CITY OF PORTLAND, MAINE  
ZONING BOARD OF APPEALS

RE: 9 Adams Street  
CBL: 084-F-012  
ZONE: IR-2 Zone

SUBJECT: INTERPRETATION APPEAL TO ALLOW THE CHANGE OF USE FROM A GARAGE (NONCONFORMING AS TO SETBACKS) INTO A LIVING SPACE 9 ADAMS STREET – PEAKS ISLAND – O84-F-012 – IR-2 ZONE

DATE: MAY 13, 2002

CONSTRUCTION PLAN

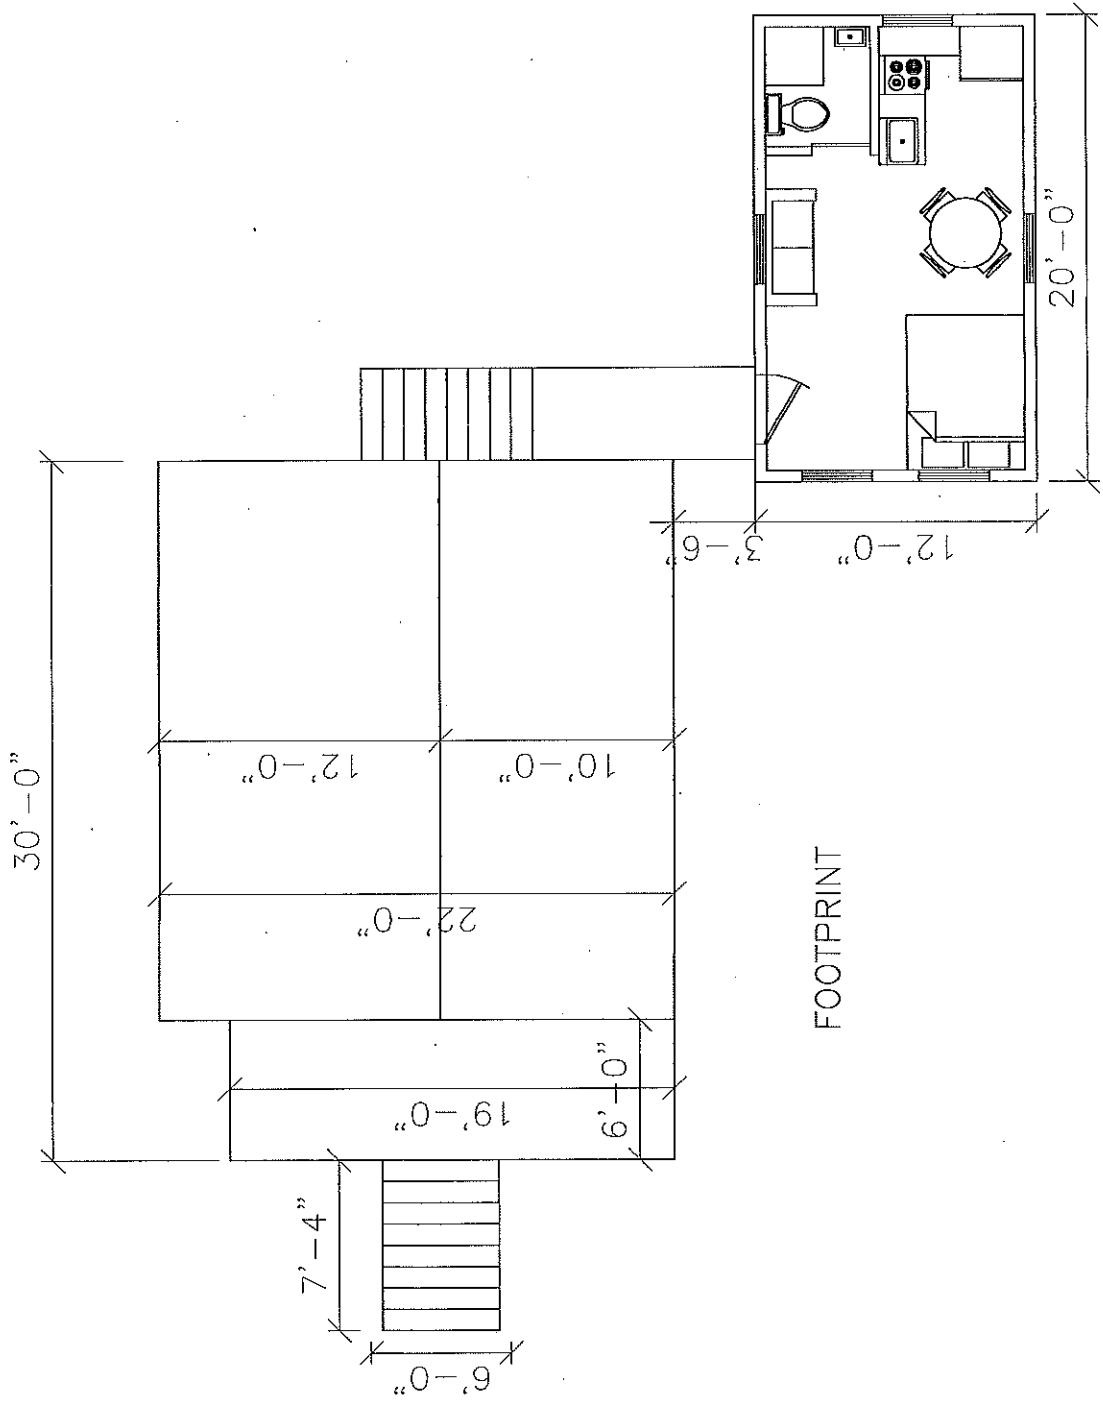
Currently, this property has a detached accessory garage/storage structure. The owners have proposed to reconfigure their house to include attaching the garage and turning it into living space. I have used the precedence of a previous appeal (January, 1990) at 48 Pitt Street to make an interpretation that any structure which is legally nonconforming as to setbacks, may continue its nonconformity under the same circumstances. However, when the use of the structure changes, it shall be made to conform to the current setbacks under the Zoning Ordinance.

I believe that the dynamics of this proposal is similar to the Pitt Street appeal. A detached, accessory structure such as a garage or storage area is fairly benign in nature. To change the use of the garage to be part of a living unit expands the principal use and makes it more nonconforming as to setbacks. It also imposes a greater impact upon the neighbors. I believe that section 14-382 (c) & (d) would apply to this proposal and its denial.
